**CITY OF ALBUQUERQUE  
PLANNING DEPARTMENT  
May 16, 2012  
DRB Comments**

**PROJECT # 1009040**

**APPLICATION # 12-70143**

**RE: Tract 8, Lands of Rossiter**

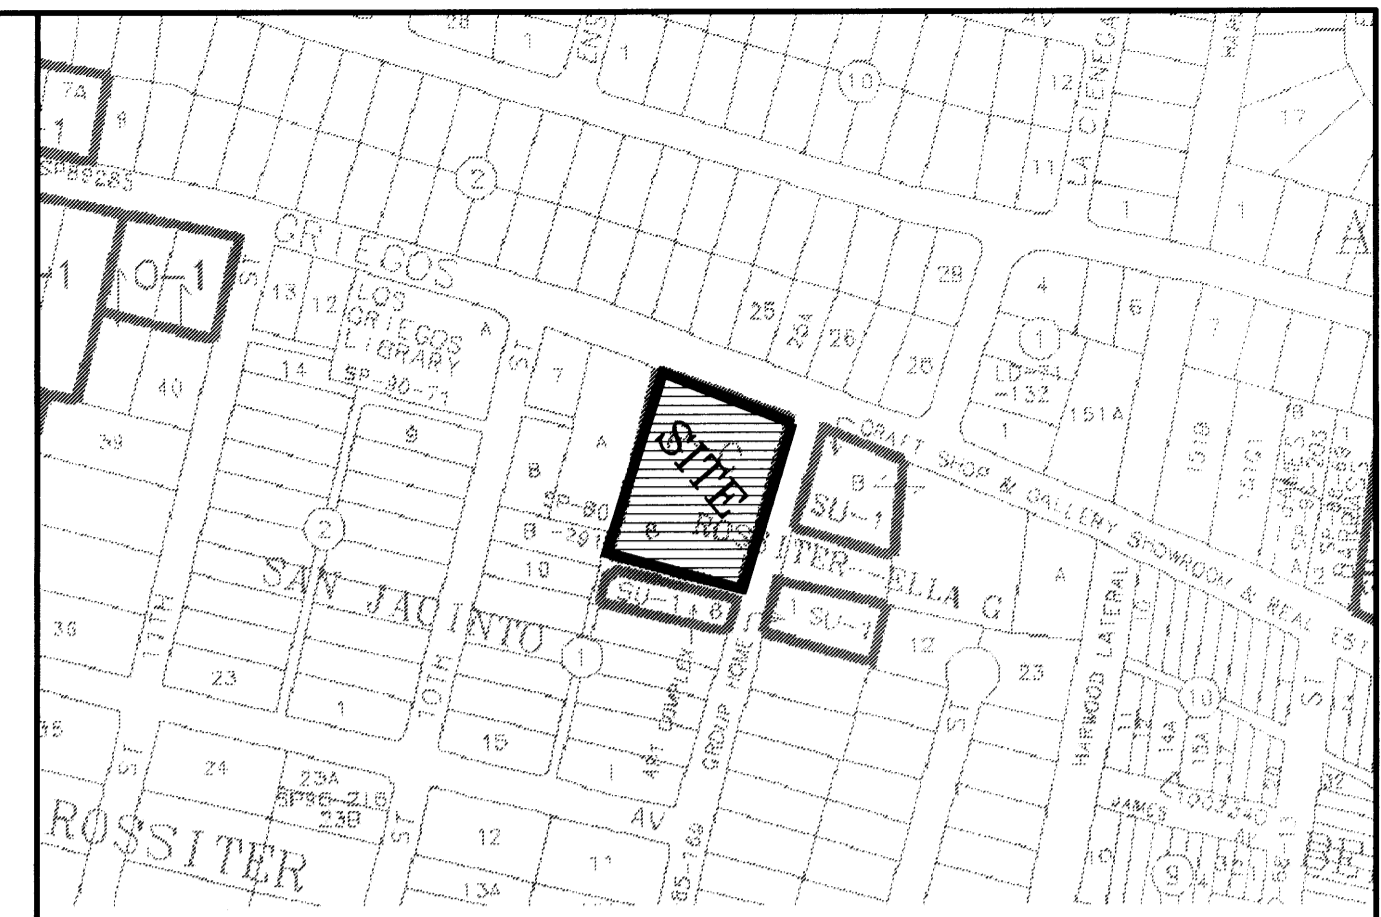
If townhouses are proposed, RC zone allows RT uses (2,200 sq ft NET – exclusive of any access easement – and 22 feet lot width per dwelling unit); the proposed development would require significant variances. It may not be advisable to have a street connect to the alley as this could encourage cut through traffic; refer to comments from Transportation Development.

ENGINEER'S SEAL	GRIEGOS AND NINTH	DRAWN BY WCWJ
	SKETCH PLAT	DATE 11-01-11
		21138-LAYOUT-11-01-11
	 <b>Rio Grande Engineering</b> 1606 CENTRAL AVENUE SE SUITE 201 ALBUQUERQUE, NM 87106 (505) 872-0999	SHEET #
DAVID SOULE P.E. #14522		JOB # 21138

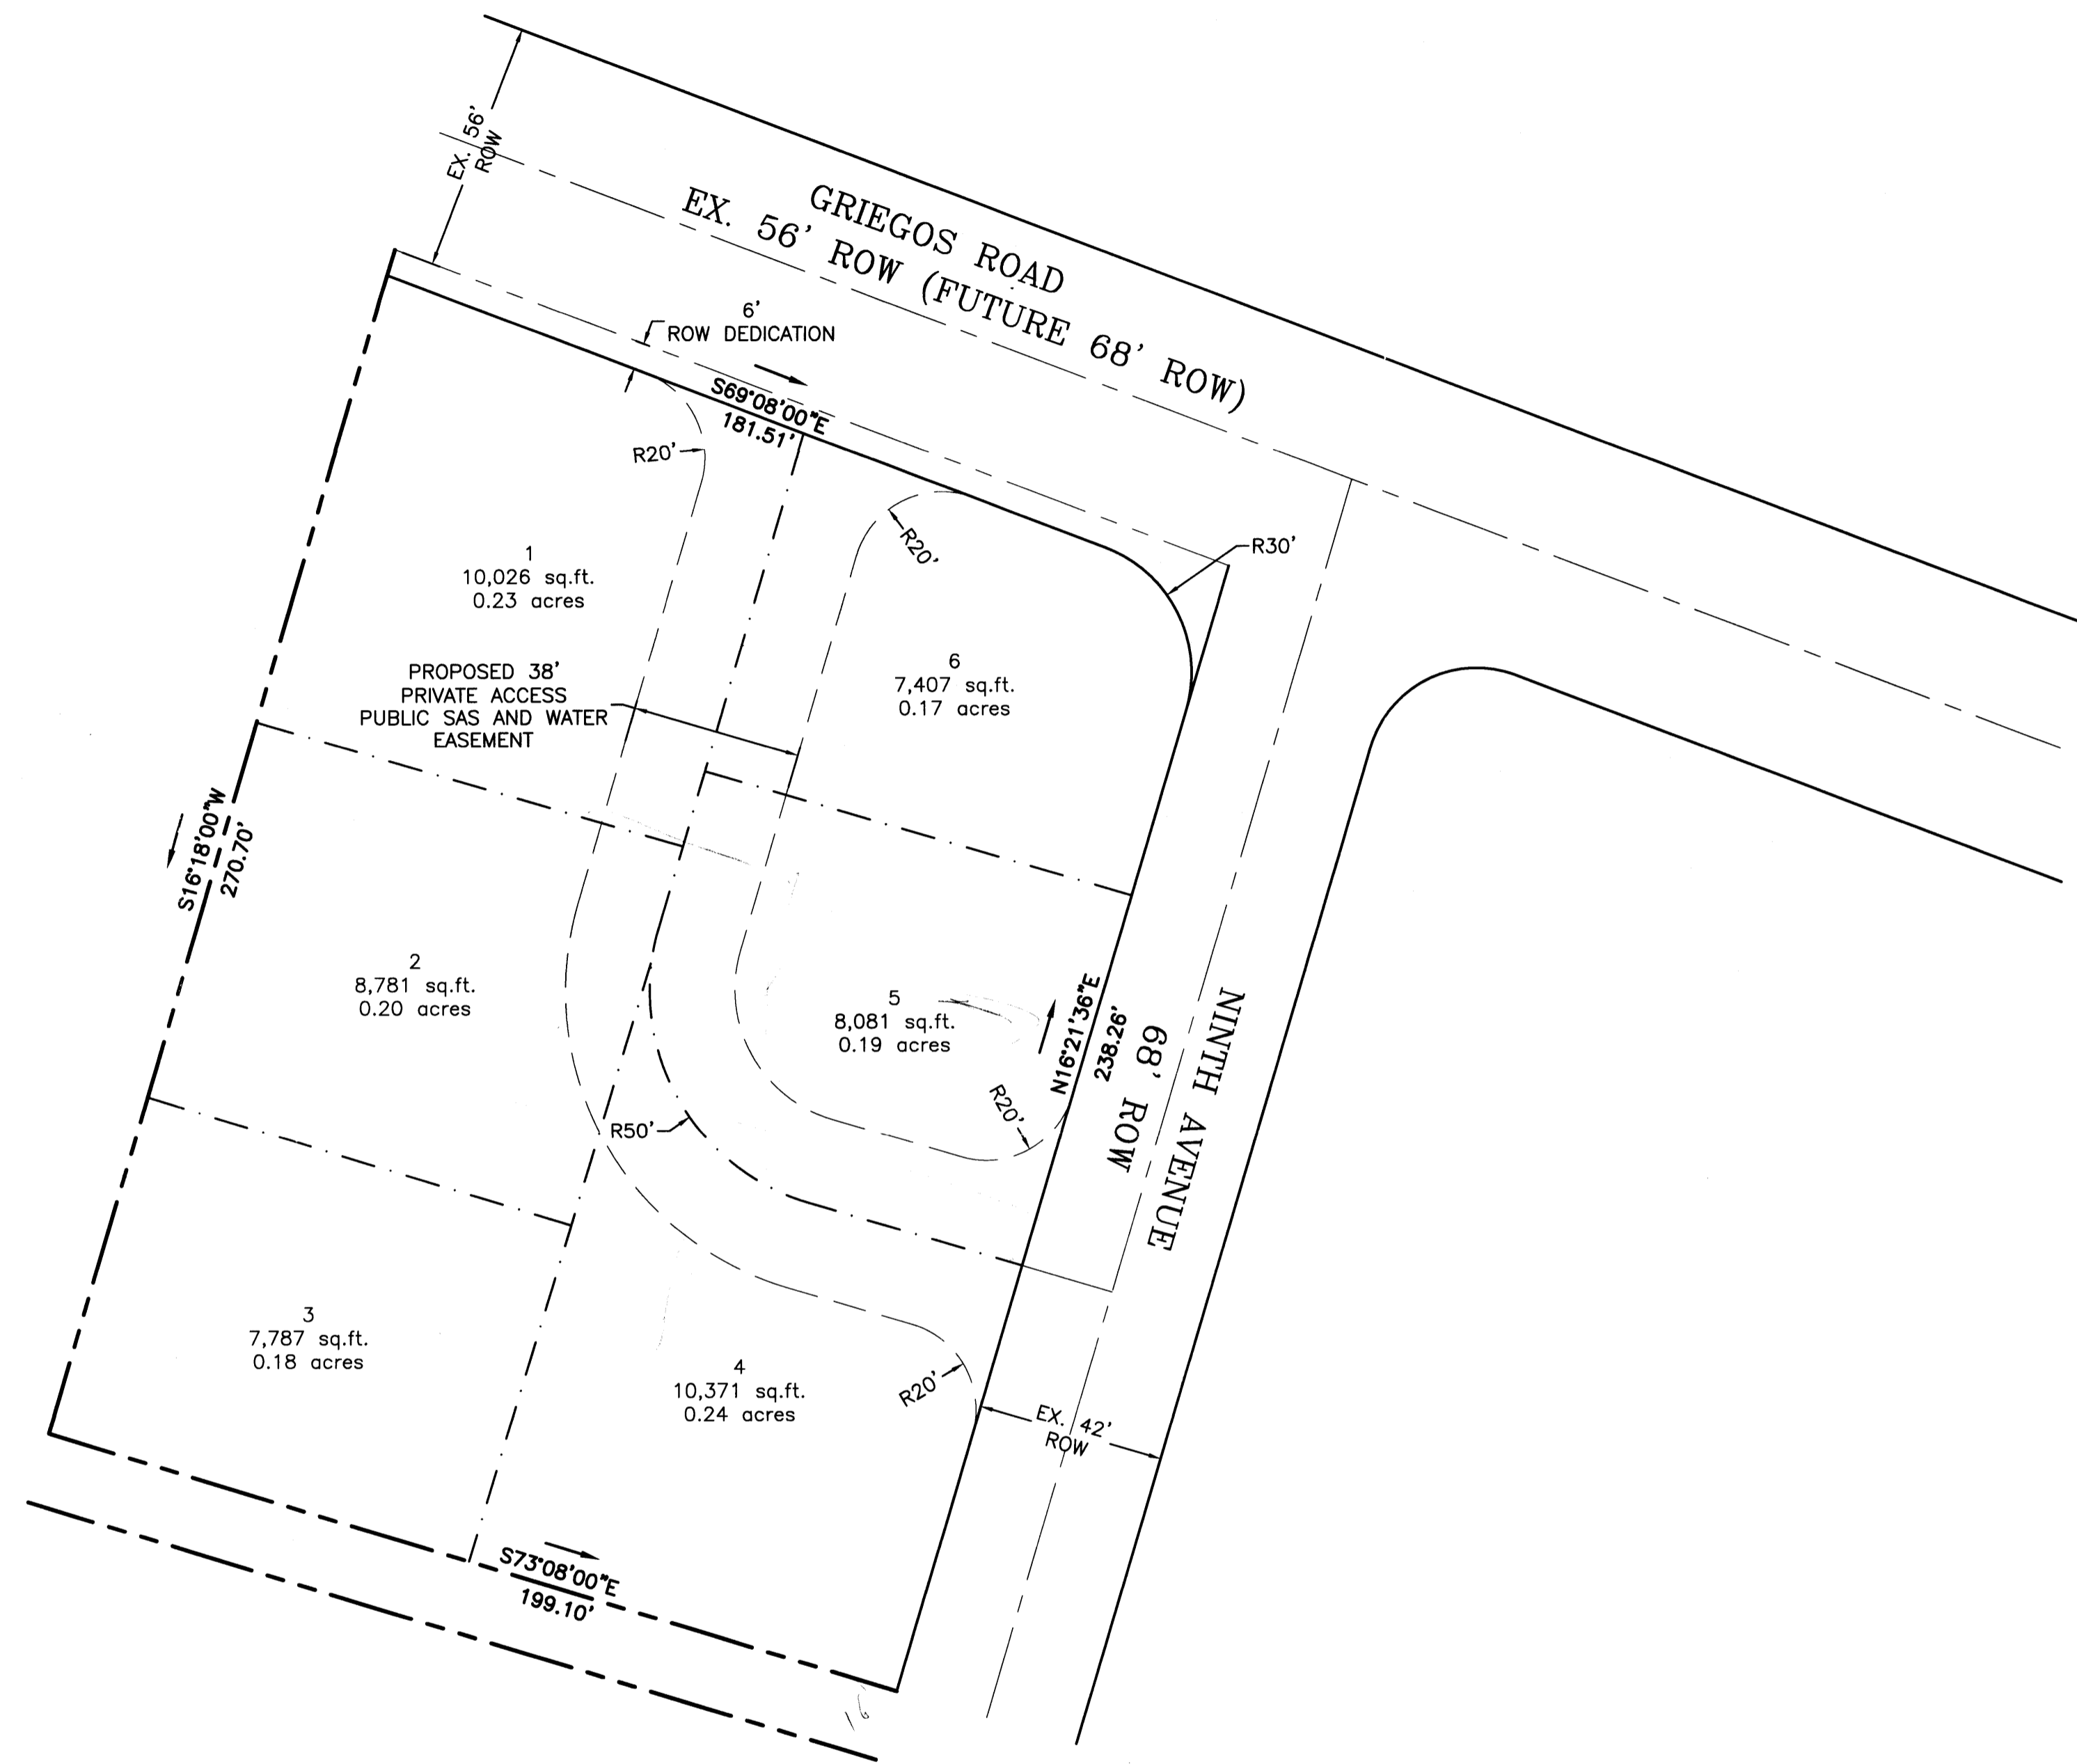
RC zone allows RT uses (3,600 sq ft NET – exclusive of any access easement). It may not be advisable to have a connecting street as this could encourage cut through traffic; refer to comments from Transportation Development. It appears a similar layout could be achieved with a hammerhead dead end street.
